**WEST SUSSEX COUNTY COUNCIL
STRATEGIC PLANNING CONSULTATION**

SUBJECT: LU/161/14/PL - Proposed Light Industrial development

LOCATION: Fort Road Garage, Fort Road East, Littlehampton, West Sussex, BN17 7QZ

This is the WSCC highways and transport response to the above planning application.

Site plan 1:200

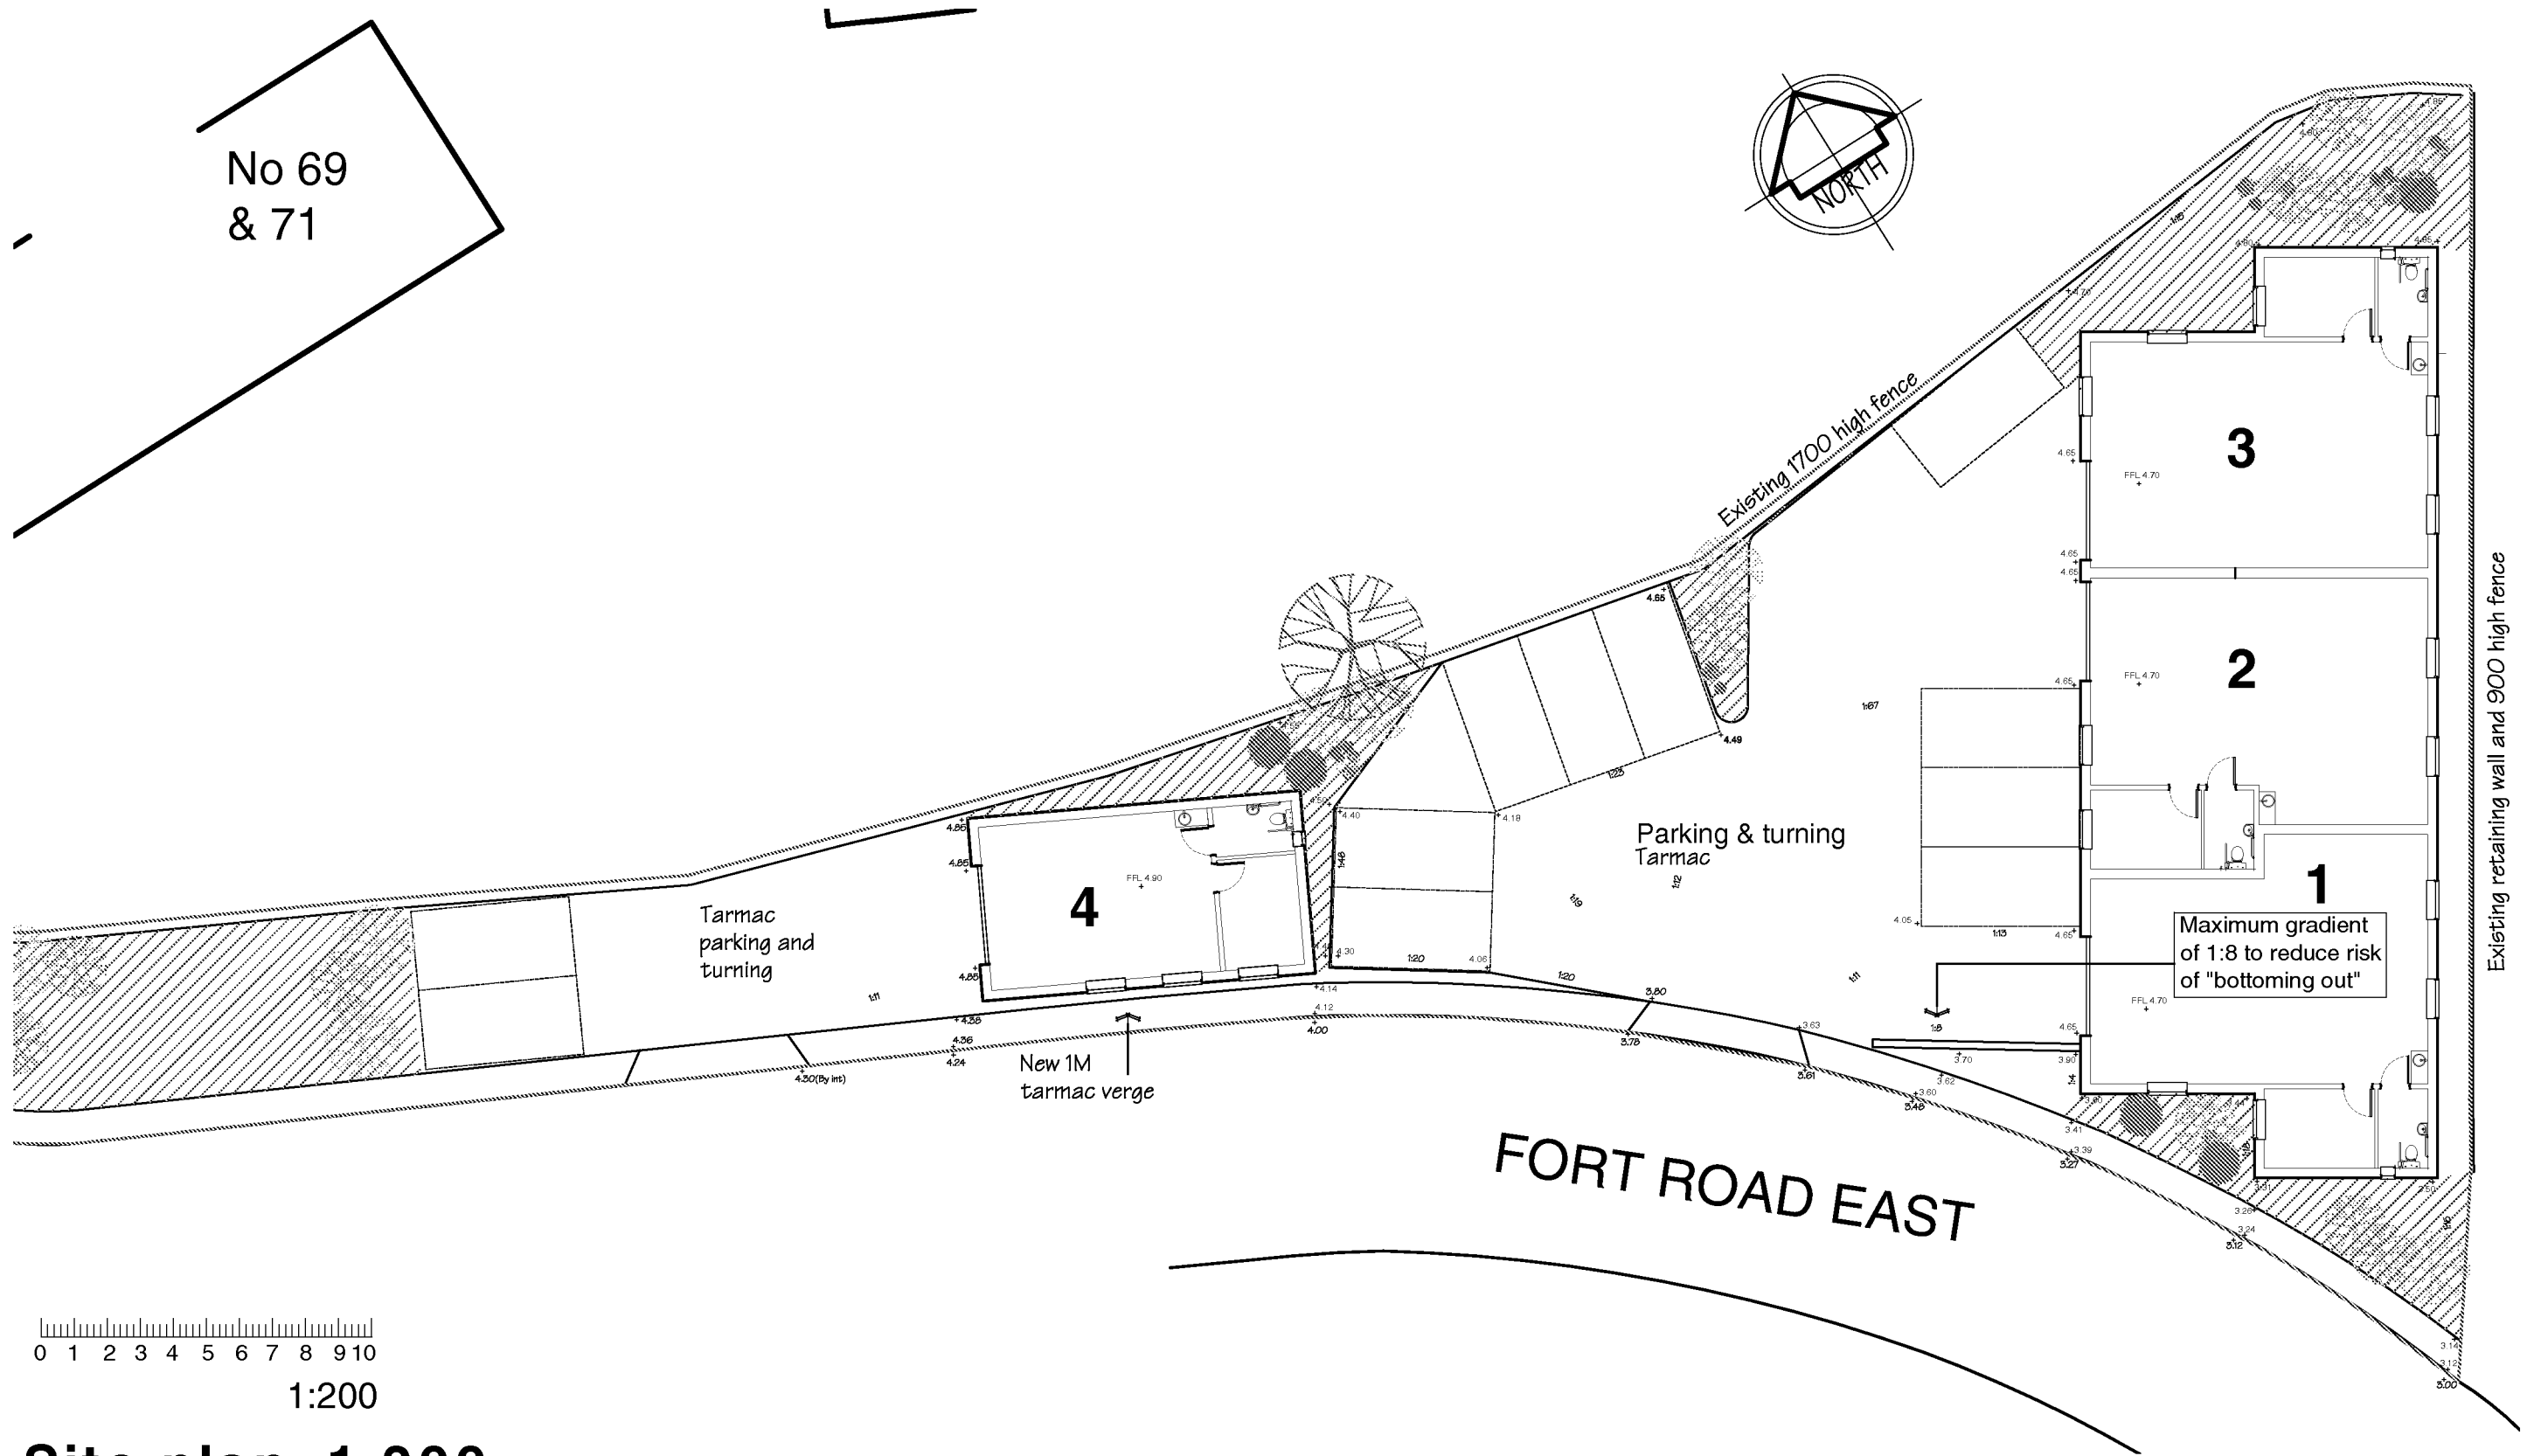
1. A 1.8m wide footway along the entire site frontage, connecting with Fort Road (to the west) – including provision to cross Fort Road East at an appropriate point along the site frontage corresponding with a crossing point on the south side of Fort Road East (red edging to be extended around this and sight lines to be shown at the crossing point).
2. A Stage 1 Road Safety Audit and Designer's Response for the footway and access points.
3. Visibility splays (including pedestrian splays) at each access point commensurate with the speed limit on Fort Road East.
4. Revised parking and building layout to reflect changes to site frontage brought about by new footway.
5. Secure and covered cycle parking to be shown on-site.
6. A Travel Plan Statement to be provided.
